Colorado Springs, CO

Final Report - Corrections Required **Application No. LUPL-25-0008**

Document Filename : 241010_BLR Village C Land Use Plan.pdf

BANNING LEWIS RANCH - VILLAGE C

PDZL-24-0005
SHEET NUMBER

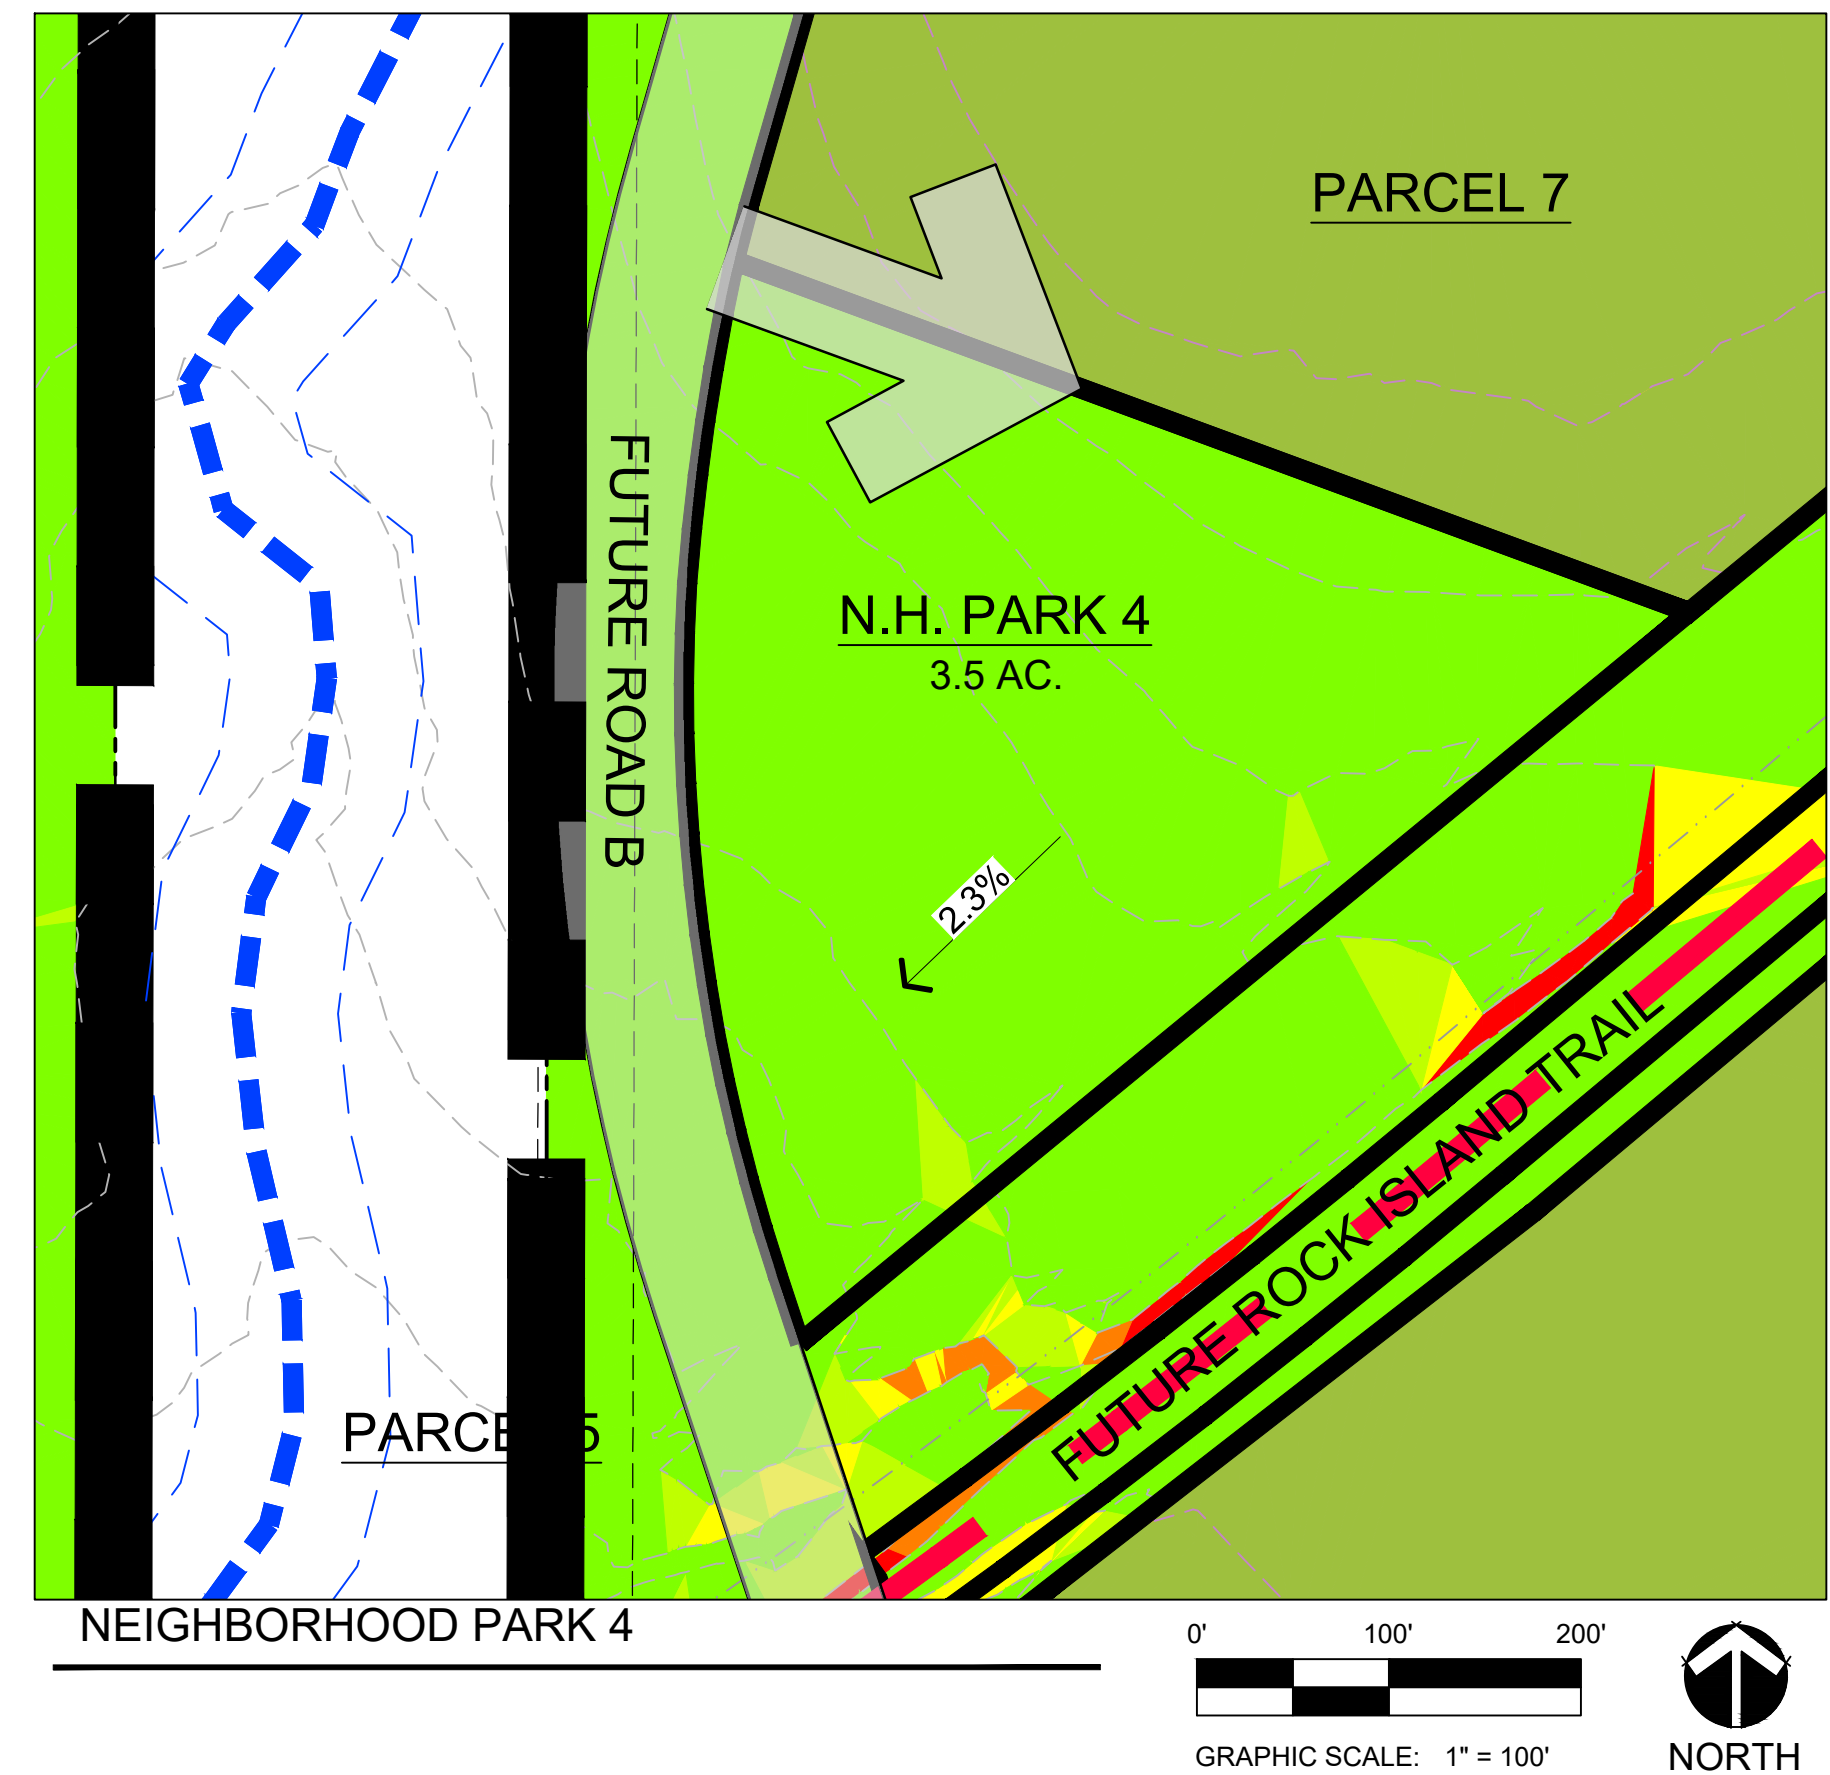
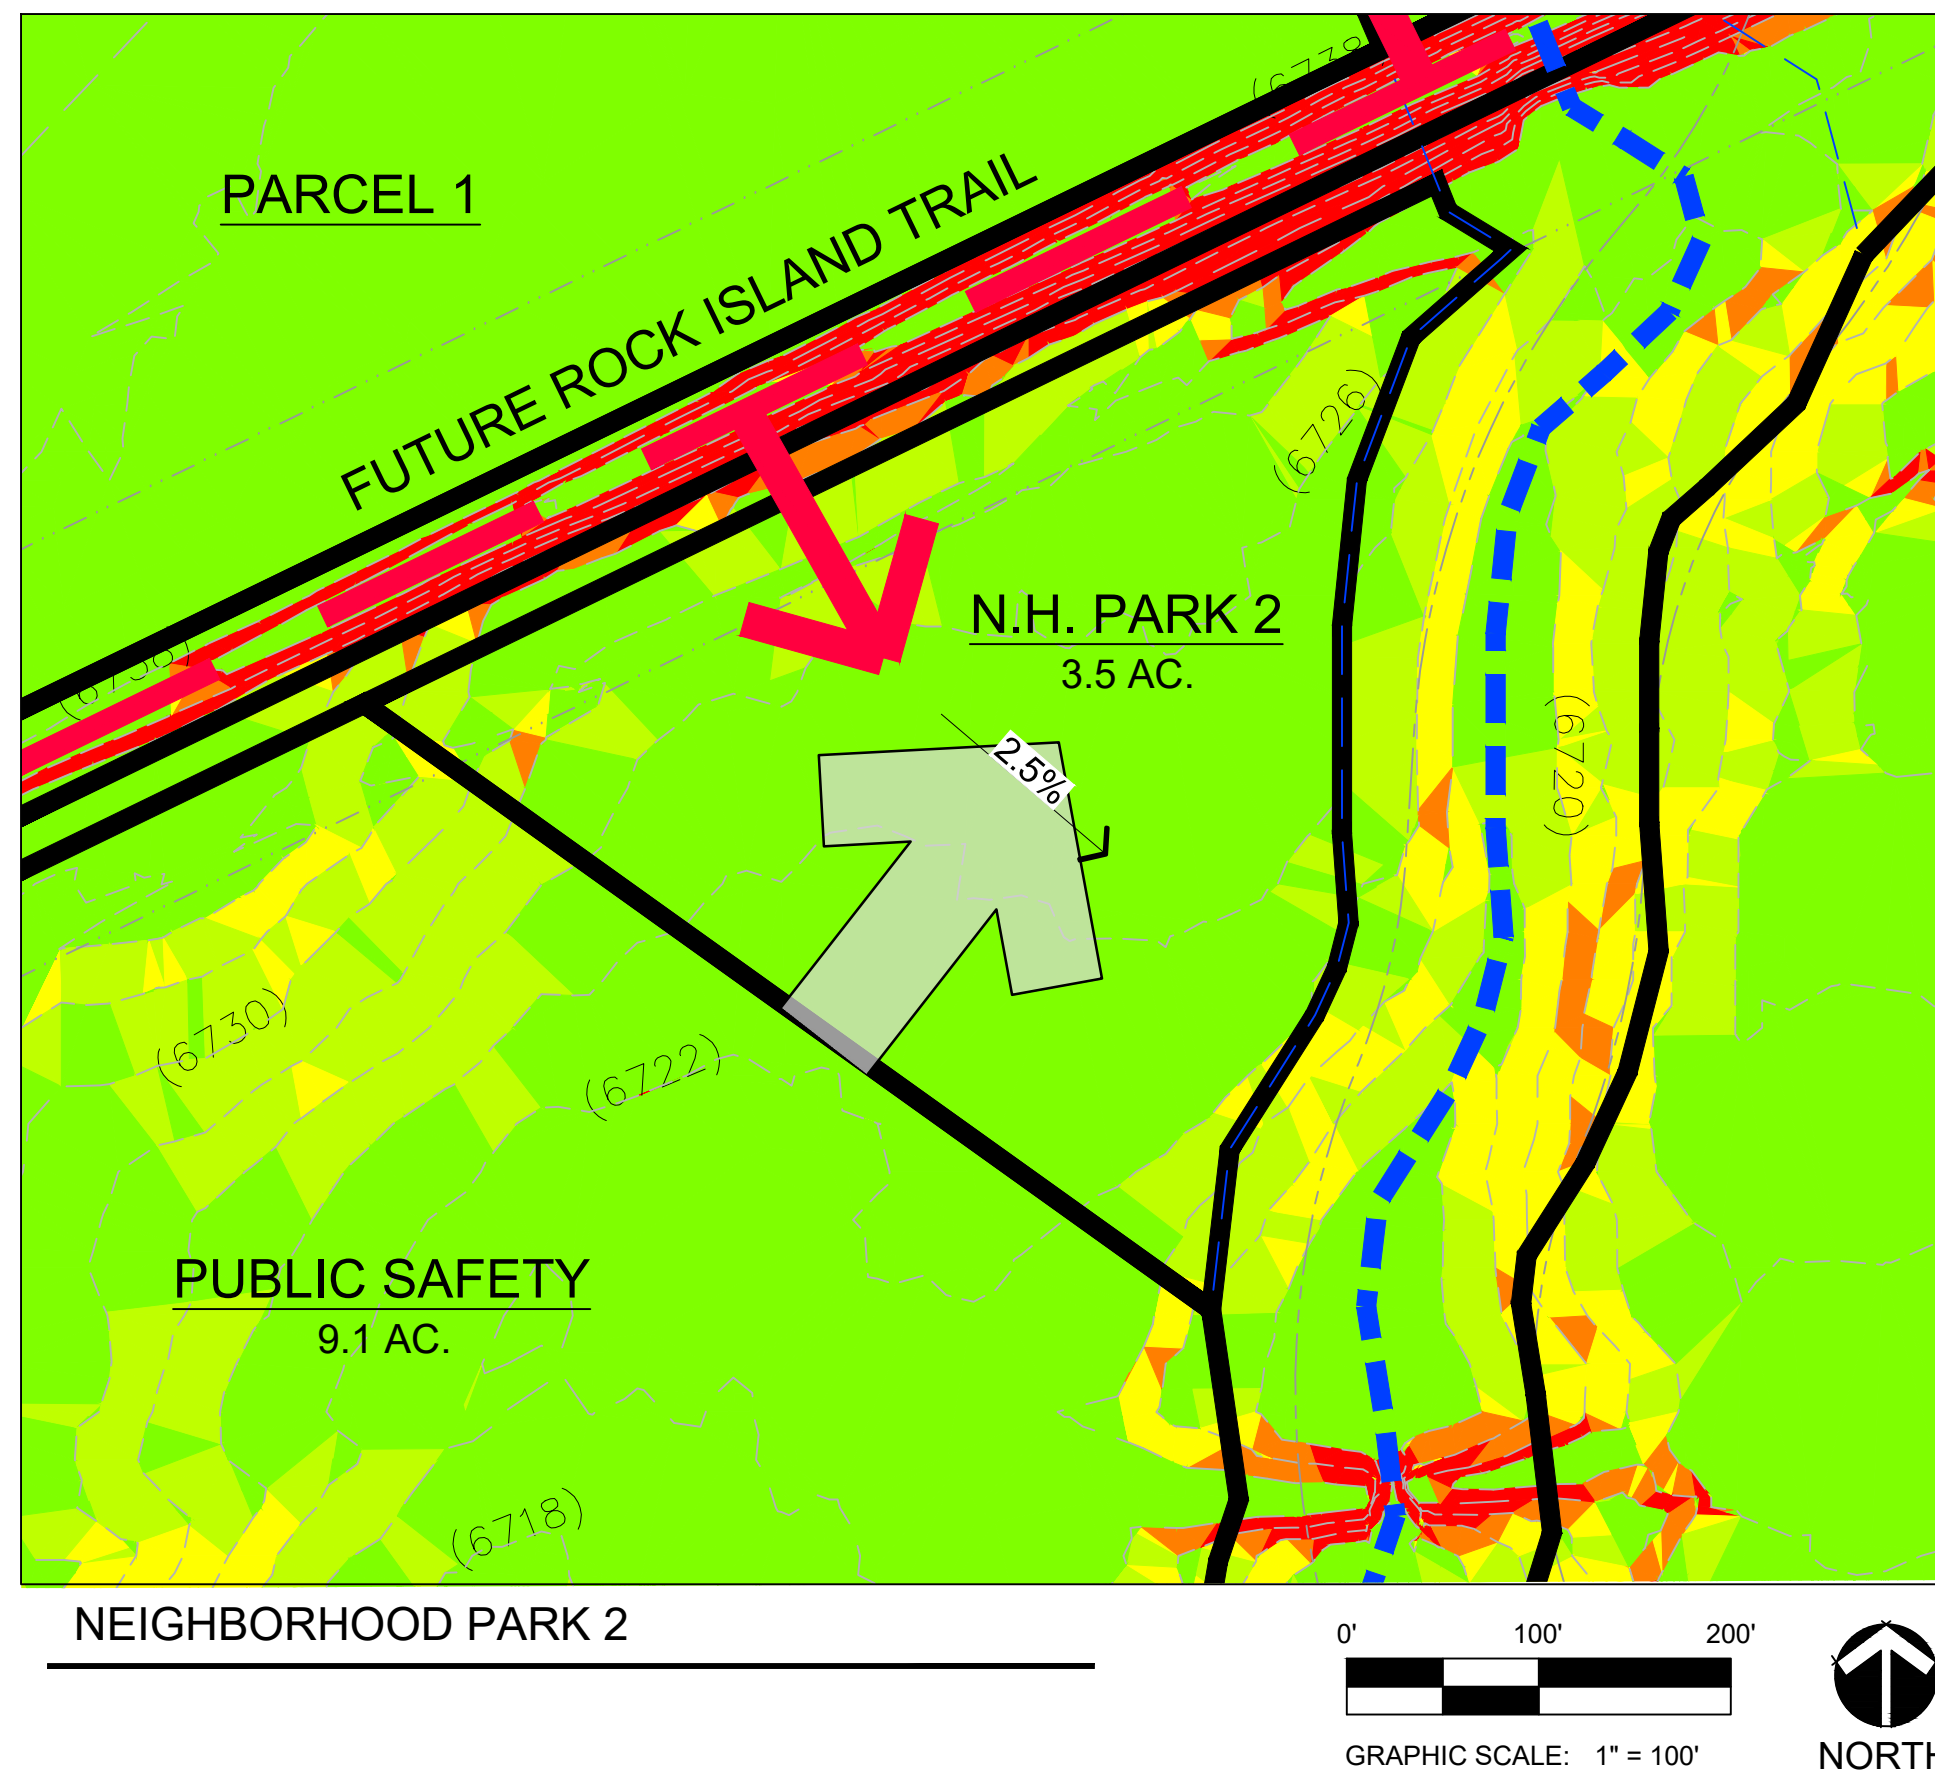
Comment ID	Page Reference	Reviewer : Department	Review Comments
16	2	Caroline Miller : Planning	Informational - More Parks comments or edits are likely to be requested.
19	2	Caroline Miller : Planning	Please revise all proposed zones - PDZ for Parks and Schools is no longer proposed.
21	2	Caroline Miller : Planning	As shown, there is a need for pedestrian bridges to allow connection to the Community Park site. Will the developer provide those?
22	2	Caroline Miller : Planning	As communicated with the developer team, May 2025, BLR Village A is to be viewed as a separate development, removing the Community obligation of Village A from Village C. Please remove all references to Village A acreage. PLDO reviewer acknowledges that with this direction, the Community Park size is required to meet B2 & C obligations is 28.7 acres, though additional acreage would be supported in creating a larger, more versatile site, and better meeting Community Park Site characteristics.

23	2	Caroline Miller : Planning	Please add Village B2 Community Park acreage to table, as it is carried over from Village B2.
24	2	Caroline Miller : Planning	Please recalculate math for Community Park obligations for Village C and B2. Reviewer calculates 11.568 for Village C and 17.128 for Village B2 with units shown.
26	2	Caroline Miller : Planning	Please confirm, in prior LUP Review (PDZL-24-0005) 1,841 units were used as an average for PLDO calculations. Now, this number has been revised to 1,446 to account for 6 du/ac (Note 1) where the mean unit count is now 2,285. Please confirm with staff which count is more accurate. Typically staff would go with average.
28	2	Caroline Miller : Planning	Notes 2 and 4 need to be updated with accurate acreages and reflect that Village A is no longer included.
29	2	Caroline Miller : Planning	Staff sees 4 3.5 acre parks totaling 14 acres of Neighborhood Parks. Are there any notes that need to be added regarding the 4th park site considering future multifamily development? Is the intent that the future multifamily development will be meeting Neighborhood Park PLDO through this dedication, with Community Park fees in lieu due? Staff is supportive of the eastern 4th park site, as it is geographically separate from the rest of Village C and a benefit to the residents there.

32	2	Allison Stocker : Planning	Label creek name and type
42	2	Tamara Baxter : Planning	Refer to EPC, EPC Engineering and District 49 comments which were uploaded to file.
43	2	Tamara Baxter : Planning	Please see separate email dated 6.25.25 from City Budget Office sent separately.
44	2	Tamara Baxter : Planning	Single Family detached are conditional use in the MX-M zone district.
45	2	Tamara Baxter : Planning	Please clarify what is intended as "Mixed-Use", does this anticipate more than commercial and residential per UDC?
46	2	Tamara Baxter : Planning	Add the AP-O and SS-O overlays to the proposed zone district labels.
47	2	Tamara Baxter : Planning	Add the "SS-O" overlay to the proposed zone district labels
49	2	Tamara Baxter : Planning	Is this both detached and attached?
50	2	Tamara Baxter : Planning	This range does not include the proposed residential density in parcel 6, 7, 8 and 9.
52	2	Tamara Baxter : Planning	The UDC does not define Mixed-Use. Can you please clarify. Does this encompass the uses that are allowed or conditional in the MX-M zone district? Are there uses that you want to restrict?

53	2	Tamara Baxter : Planning	Please use this on the coversheet as well.
54	2	Tamara Baxter : Planning	What does this residential encompass?
30	3	Caroline Miller : Planning	This graphic doesn't match the LUP Bubbles shown on page 2, park is not next to Public Safety.
